Application No: LU/112/22/PL

Recommendation Report for Planning Permission

LOCATION: 135A Wick Street
Littlehampton
BN17 7JY

PROPOSAL: Extension to form 1 No studio flat at first floor level. This application is in CIL Zone 4 (Zero Rated) as flats.

SCALE / 1:100 @ A3
DATE / 10.12.2015
DWG.NO / 021115/TP.02REV.C

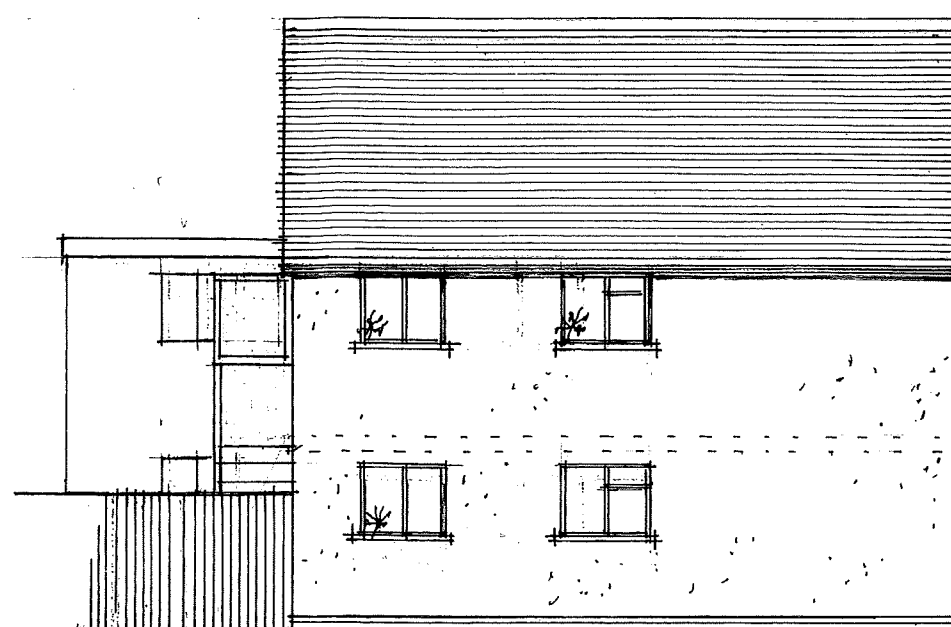
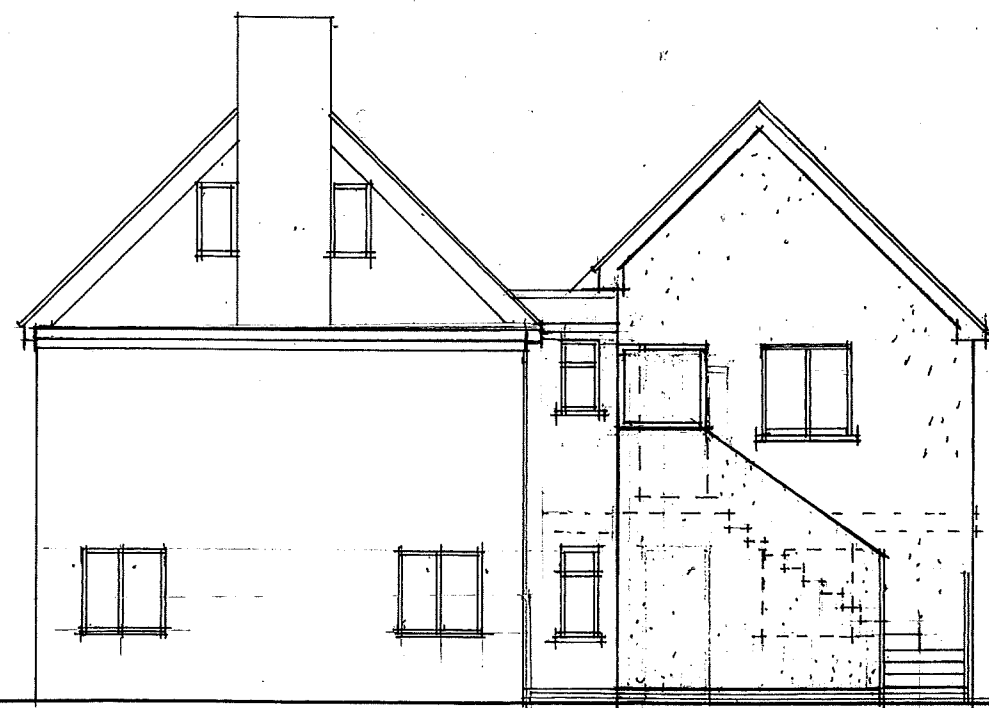
The 2nd south facing window is the primary window to the first floor flat serving an open plan living room/kitchen area. The staircase which enables access to the first floor will have an obscured glazed screen to the top of the stairwell to restrict views into the window which is located behind. This will have a height from the top of finished stair level of approximately 1.8m. As such this will partially block the view out of that window. The privacy of the window will be protected by the glazed screen and due to its opaque nature, a loss of light will be minimal. The development will have some adverse effect in terms of an overbearing impact.

The first floor southern facing window to the neighbouring flat will experience some overbearing impact caused by the development which alongside the glazed screening would intersect a 45 degree line drawn from the centre of the window. One of the panels of the window would be obscured entirely by the glazed panels at the top of the stairway. The development would protect privacy and provide an acceptable level of daylight into the primary first floor habitable room window concerned.

The Arun Design Guide states 'The scale and massing of all new housing should follow the 45-degree and 60-degree rules: minimising overshadowing and maximising privacy by keeping single-storey elements of neighbouring buildings within a 45-degree line and two-storey and higher elements within a 60-degree line taken from the edge of the nearest ground and first floor windows of habitable rooms in the neighbouring property.' The proposal conflicts with this, with the staircase intersecting a 45 and 60 degree angle when looking east.

- 3 The two obscure glazed screens to the west and north elevations of the first floor external staircase landing shown on the approved plans (TP.02 Rev C) shall be installed prior to first use of the staircase and retained in perpetuity to a height of 1.8m from finished floor level.

DWG. NO / 021115/TP.01.REV.C

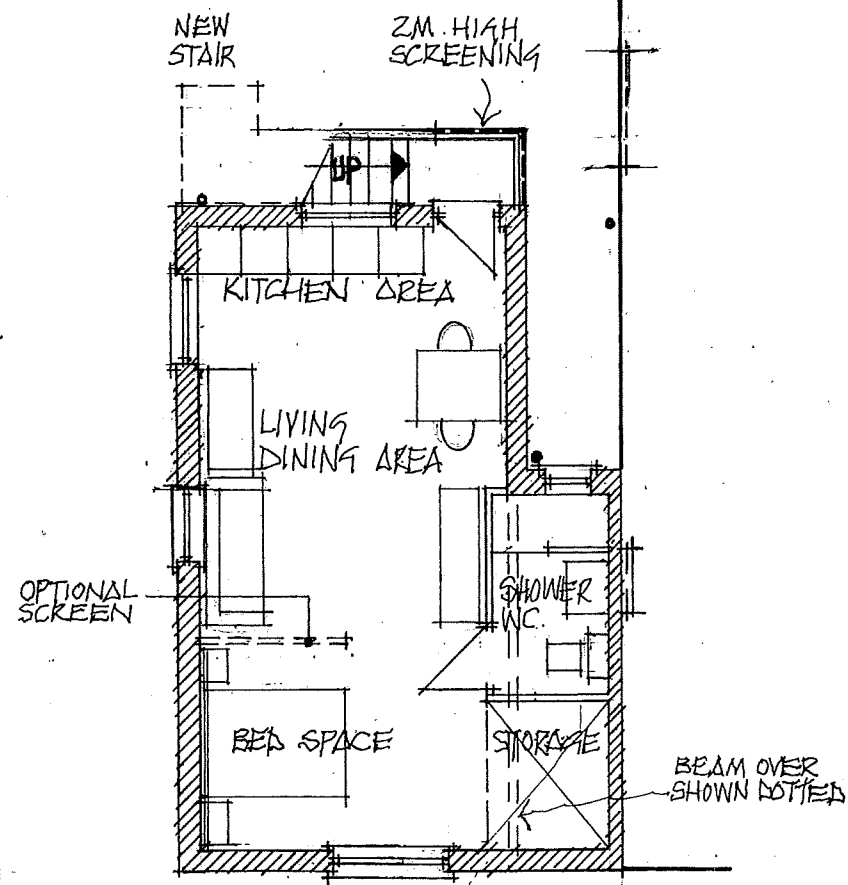
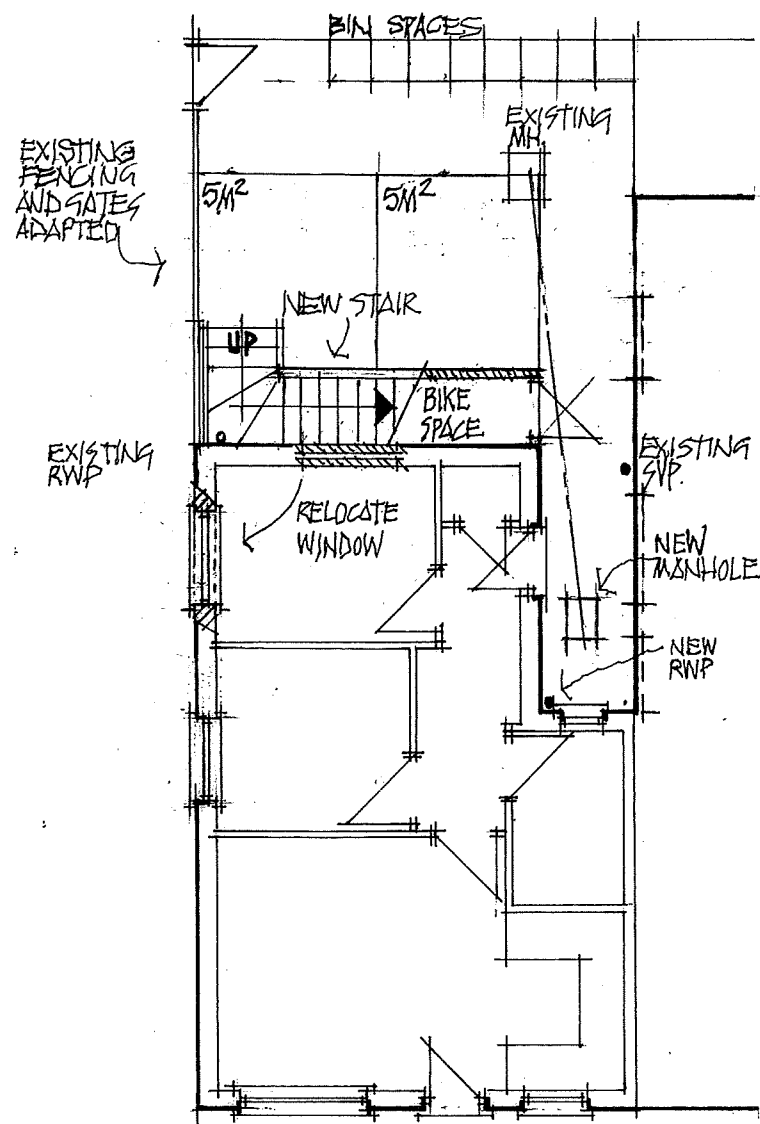
The proposal provides 41sqm and complies with the guidance for a 1 person, 1 bed unit.

WSSC have no objection and note cycle storage provision should be provided. Due to the size of the site, the ability to provide a secure and covered facility is constrained. The floor plan does demonstrate a bike space to the rear of the property underneath the staircase. Details for this will be secured by condition to encourage residents to use bicycles. As such, there is no conflict with policy T SP1.

- 4 No part of the development shall be first occupied until covered and secure cycle parking spaces have been provided in accordance with plans and details submitted to and approved by the Local Planning Authority. The spaces so approved shall be retained in perpetuity.
